Application No: M/91/21/PL
Site Address: 27 Central Drive Middleton-On-Sea PO22 7TT
Description of works: Variation of condition 2-approved plans & removal of condition 4-materials included on plans imposed under M/25/19/PL.

Thank you for your internet representation made on 22nd July 2021 which has been recorded as an objection with the comments as follows:

PROJECT	27 Central Drive - Elmer Beach	DATE	16/09/18
TITLE	Proposed South Elevation	DRG NO	IBA/507/05
SCALE	1 : 50	REVISIONS	B

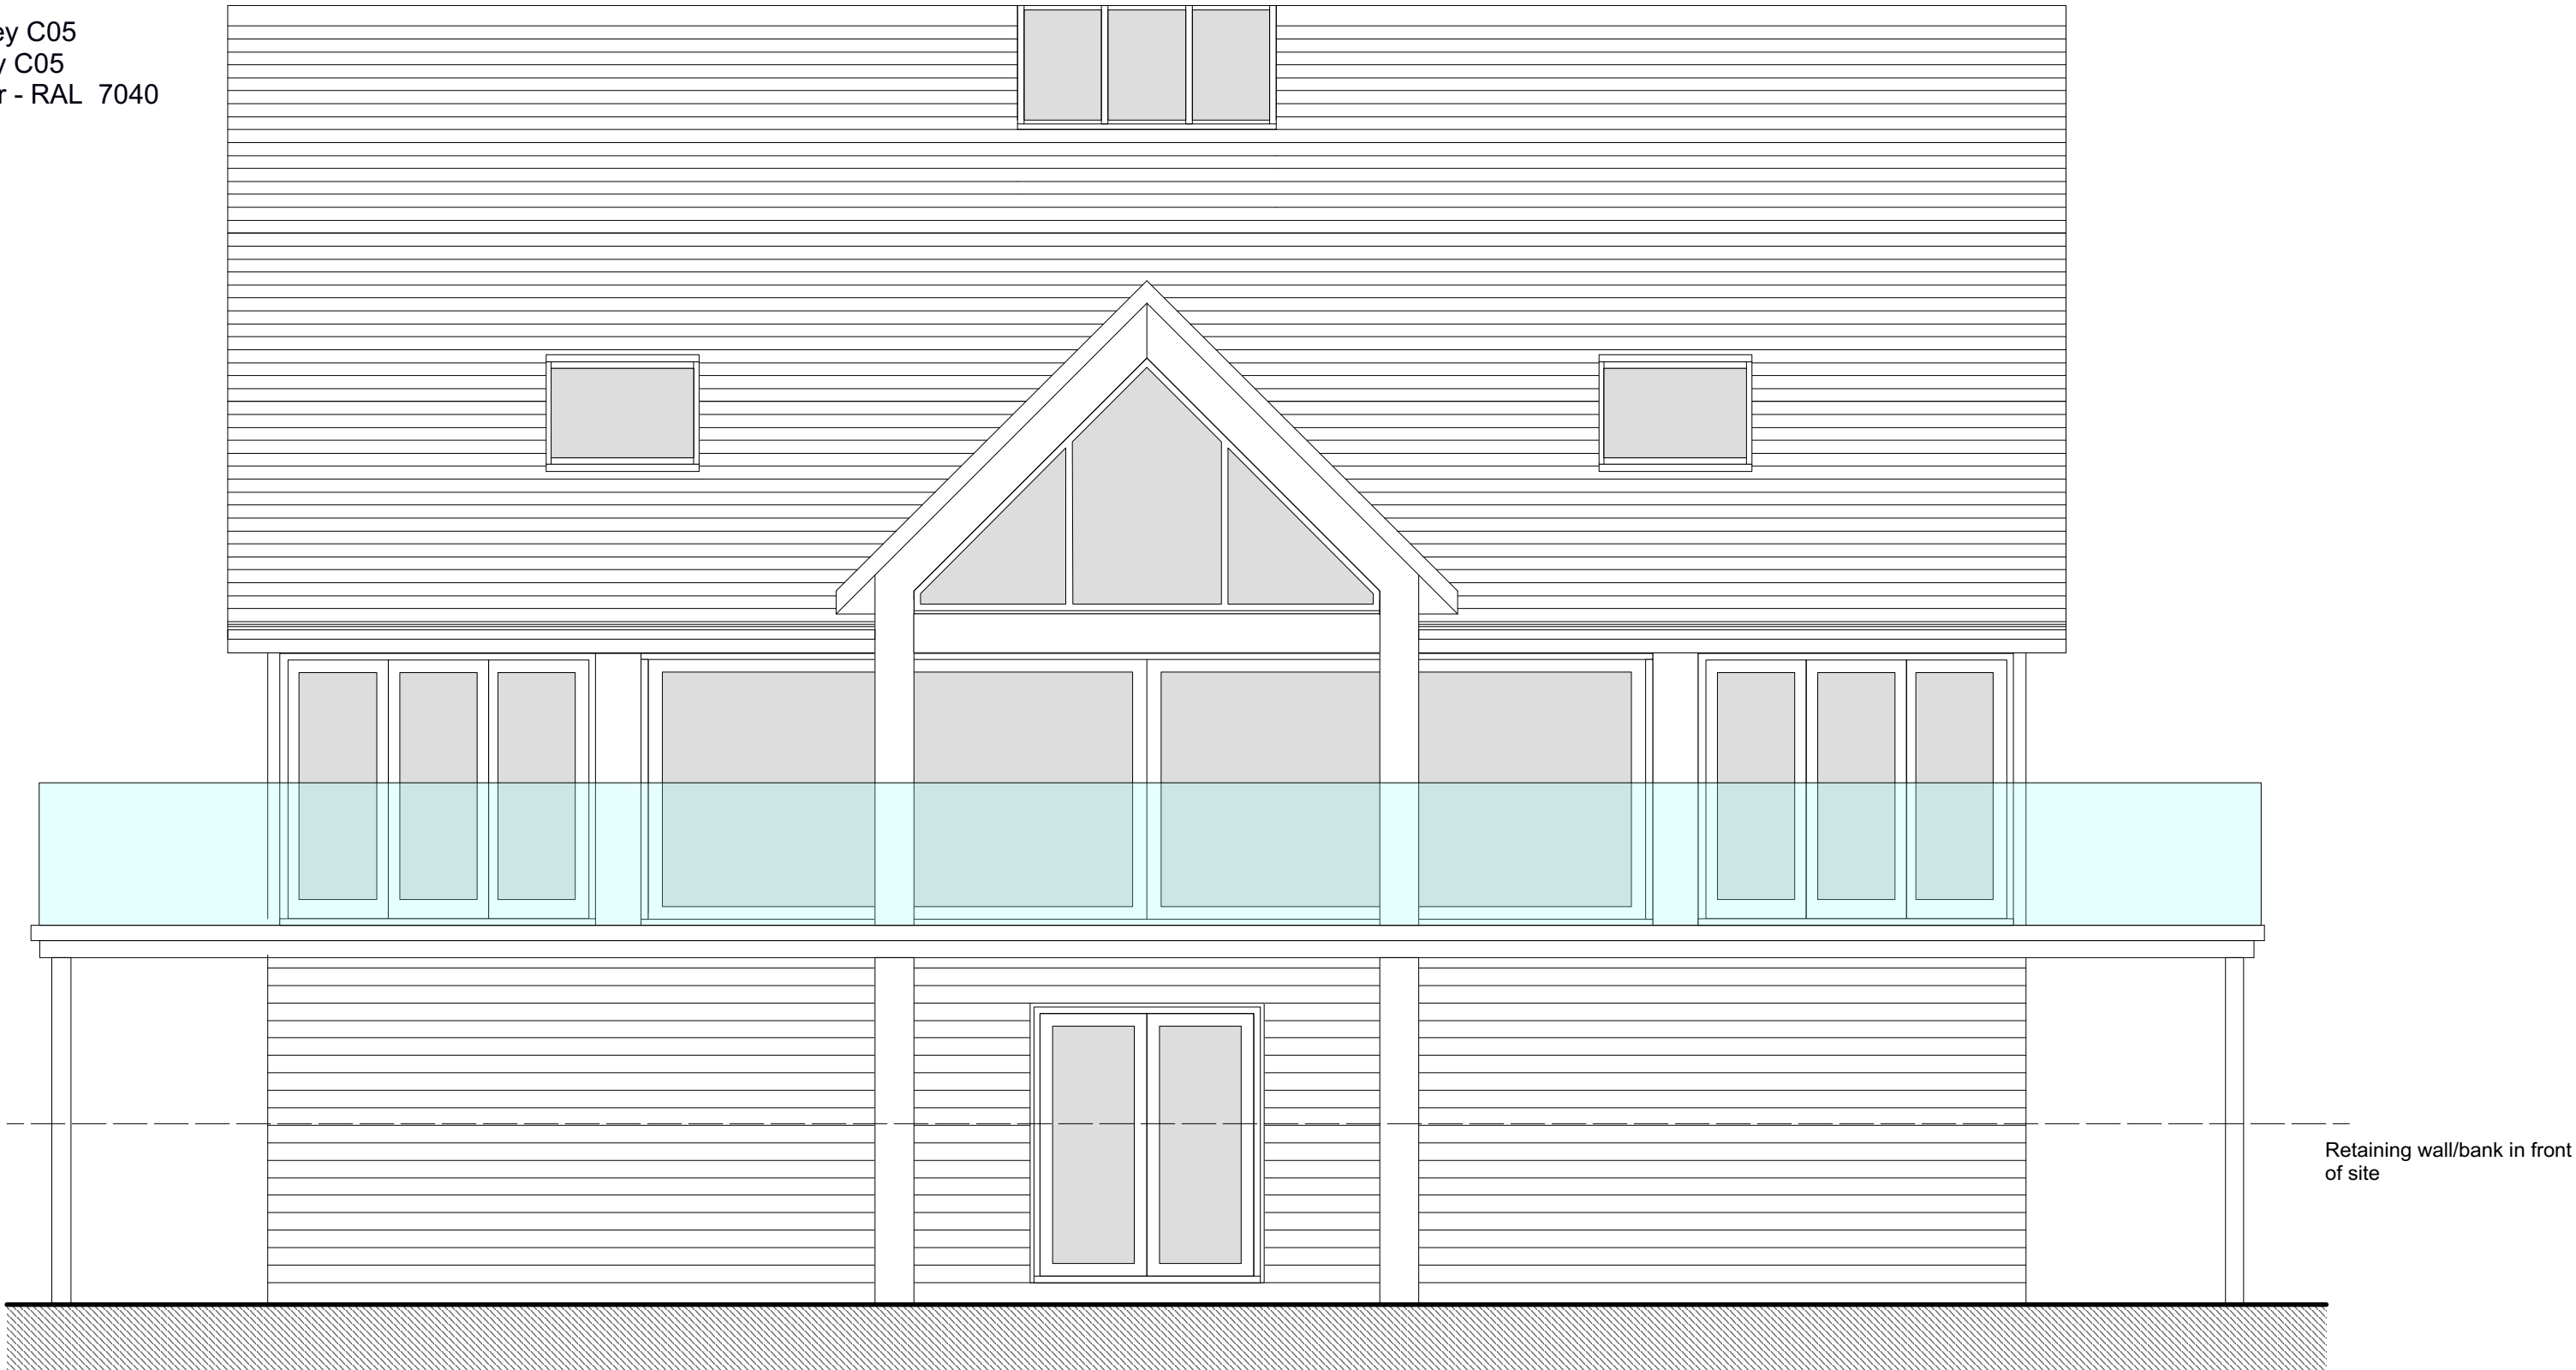
These drawings, both the north and south elevations and the "street scene" purported to show the proposed building as being very close in height to the neighbouring property. The building should have been constructed accordingly. Instead it is quite out of proportion with its surroundings and is an overbearing presence both from within the Estate and, perhaps more importantly - certainly more evidently - from the beach.

The public at large will have formed their opinion on the basis of the illustrations which specifically included the height of the next door property and few will have had the capacity to check the proposed measurements. It is clear therefore that either the original drawings were incorrect and misleading or the present height of the construction is not in accordance with approval.
